Re: Tract 11 ABCWUA Access Explanation – Bulk Land Plat Innovation Park III Tracts A-N  
(PR-2023-008999 / SD-2024-00013)

PROJECT NO. PR-2023-008999

Application No. SD-2024-00013

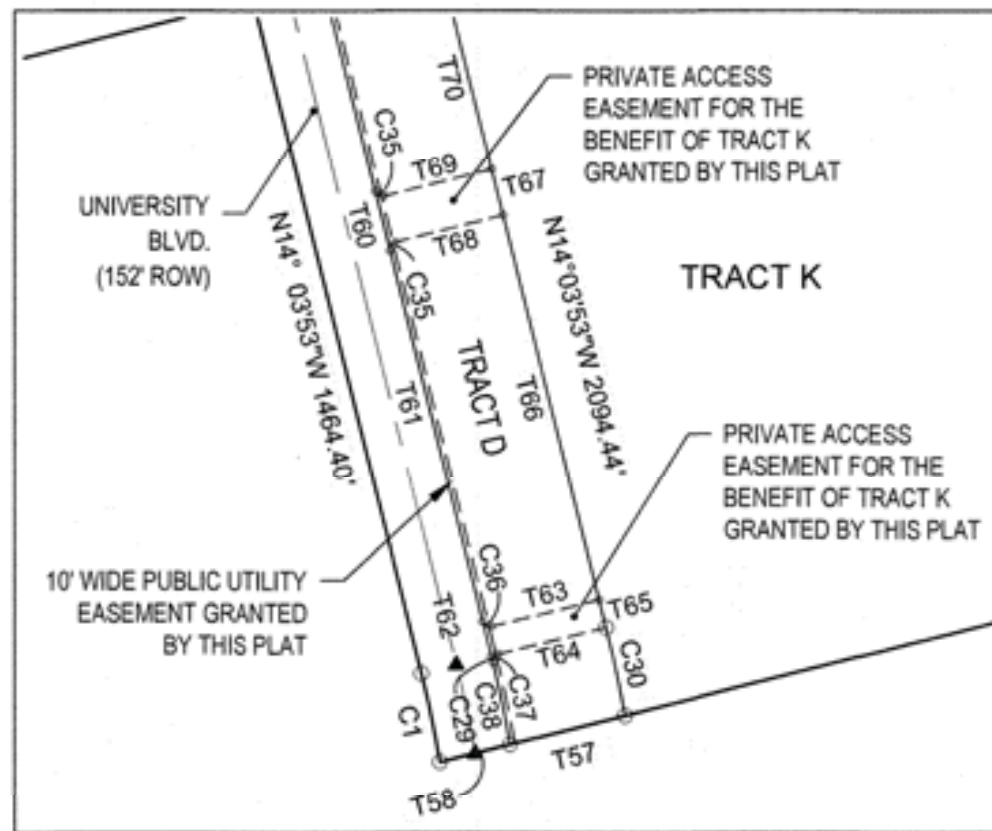
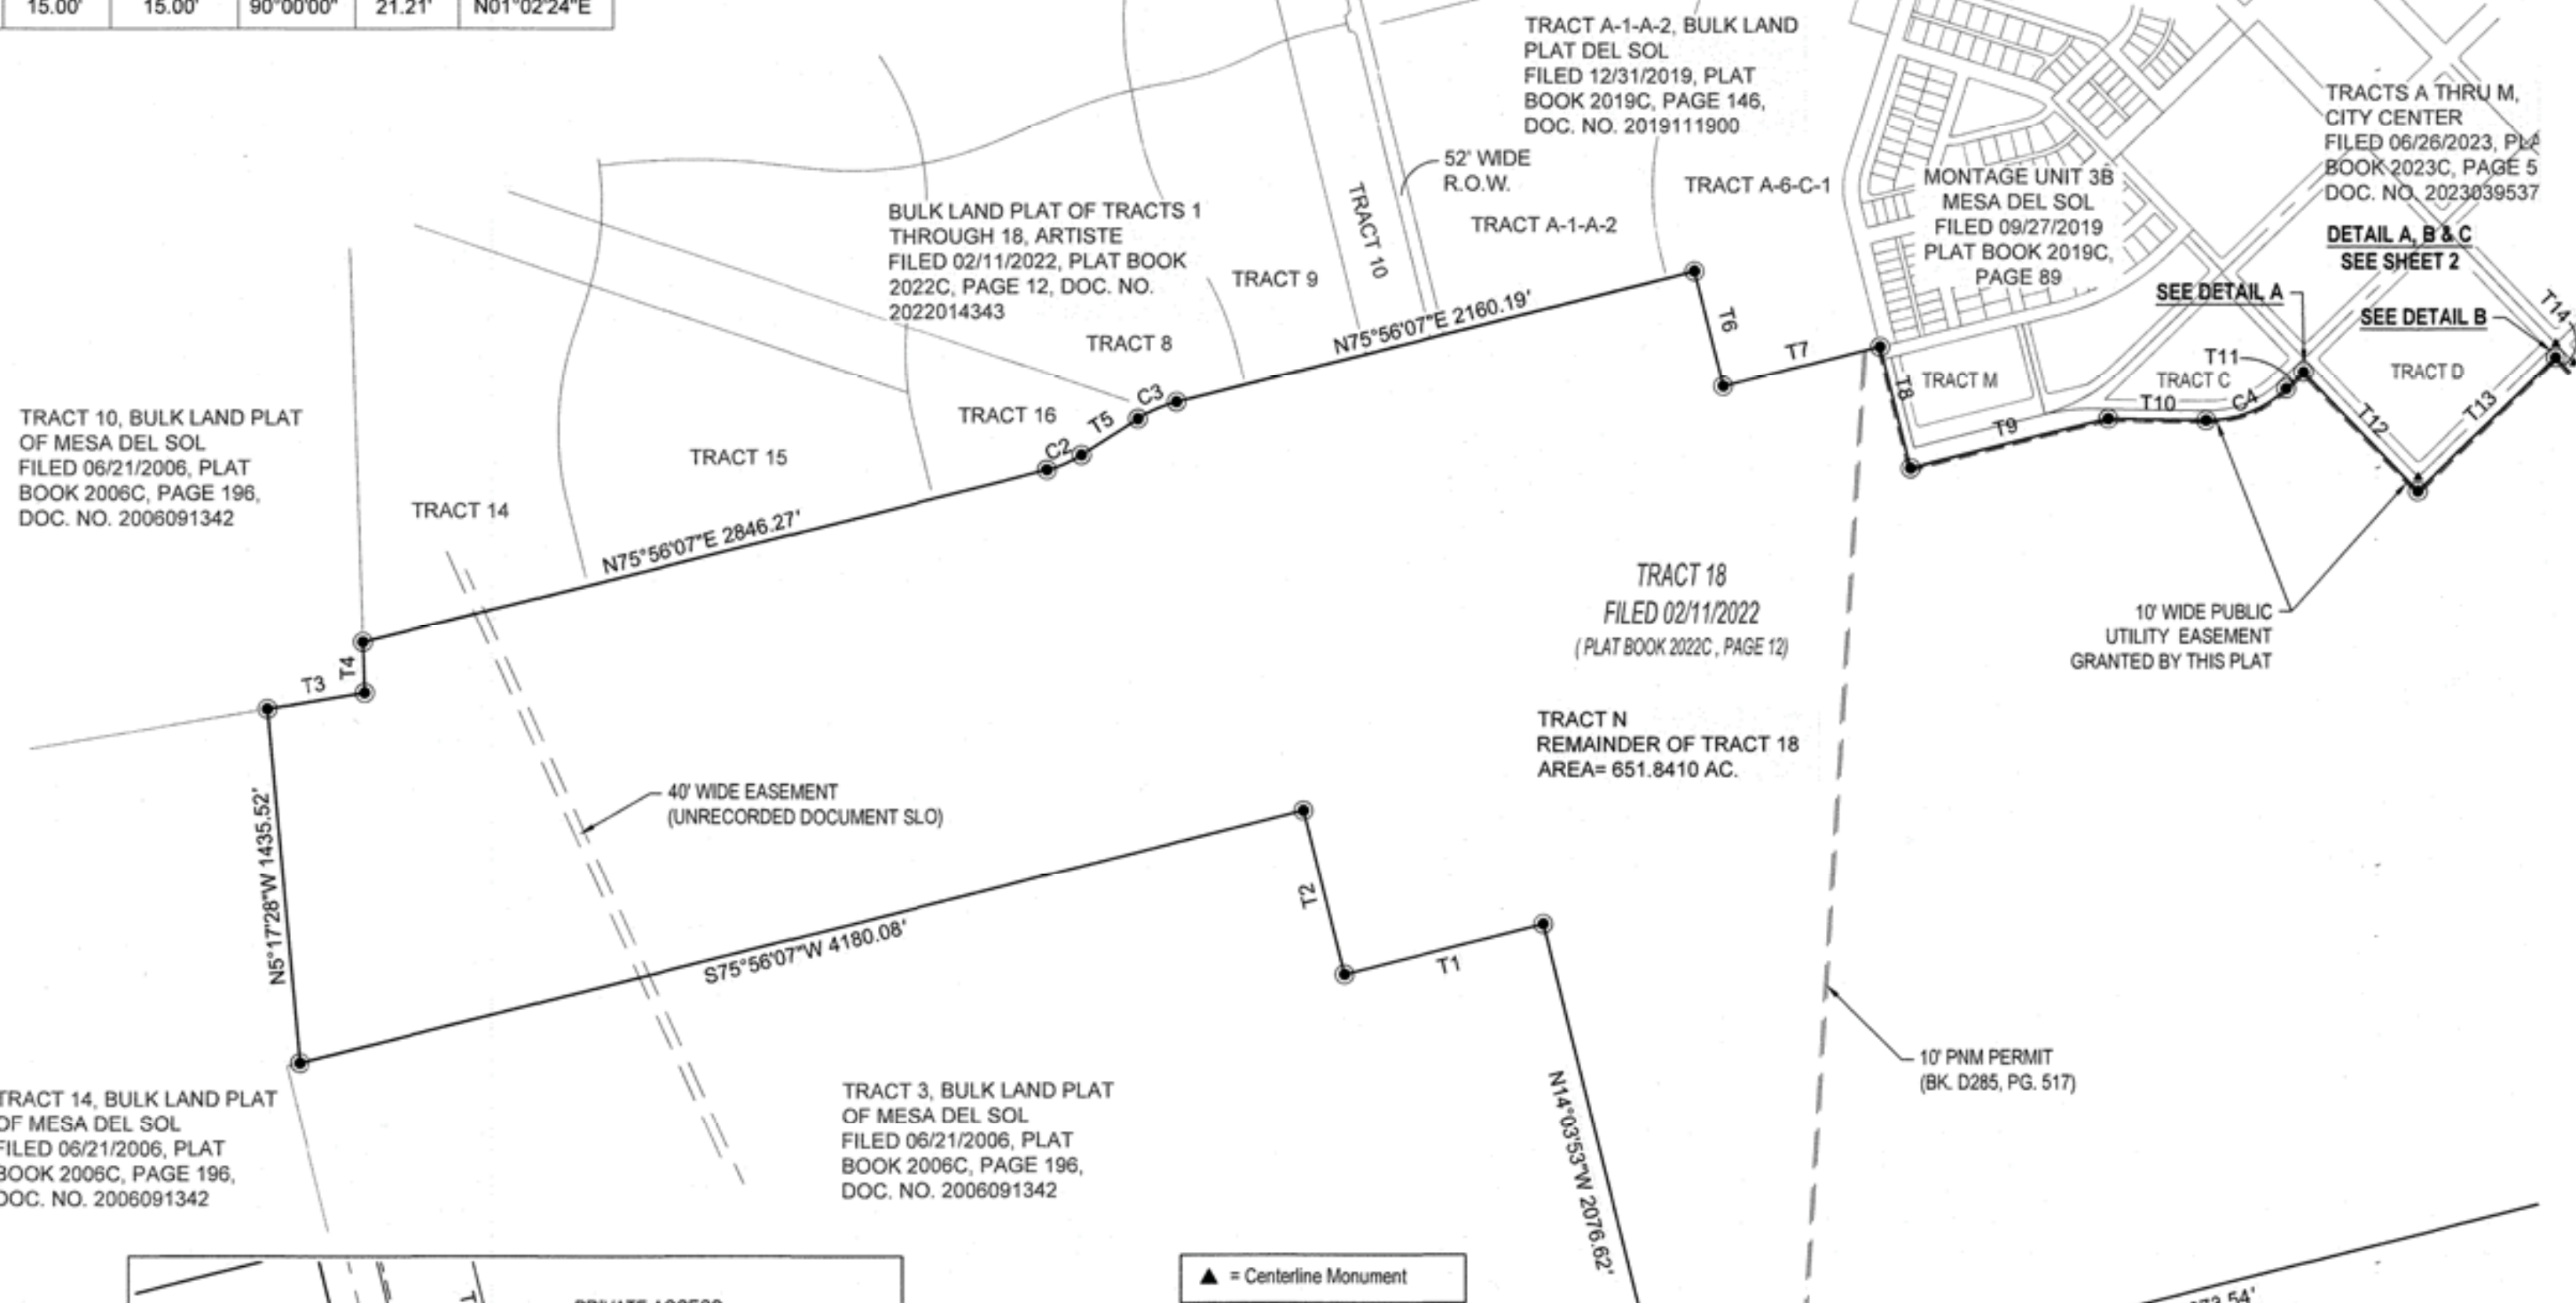
To address your concerns heard at the DHO hearings on February 7<sup>th</sup> and 28<sup>th</sup> for the above-mentioned plat we have noted on sheet 2 of 3, in detail E, an easement which will be granted by the filing and recording of this plat. The 114' wide easement will be located at the end of the Cul-de-sac in order to serve Tract, 11 if ever necessary, and will provide Public Roadway access and Public Water and Sewer access to the ABCWUA.

**DESCRIPTION:** To address comments from the ABCWUA we have added an Easement which will grant access to Public Roadway

and the Public Water and Sewer access to serve the ABCWUA. It is located at the end of the Cul-de-sac to serve Tract 11 if ever necessary.
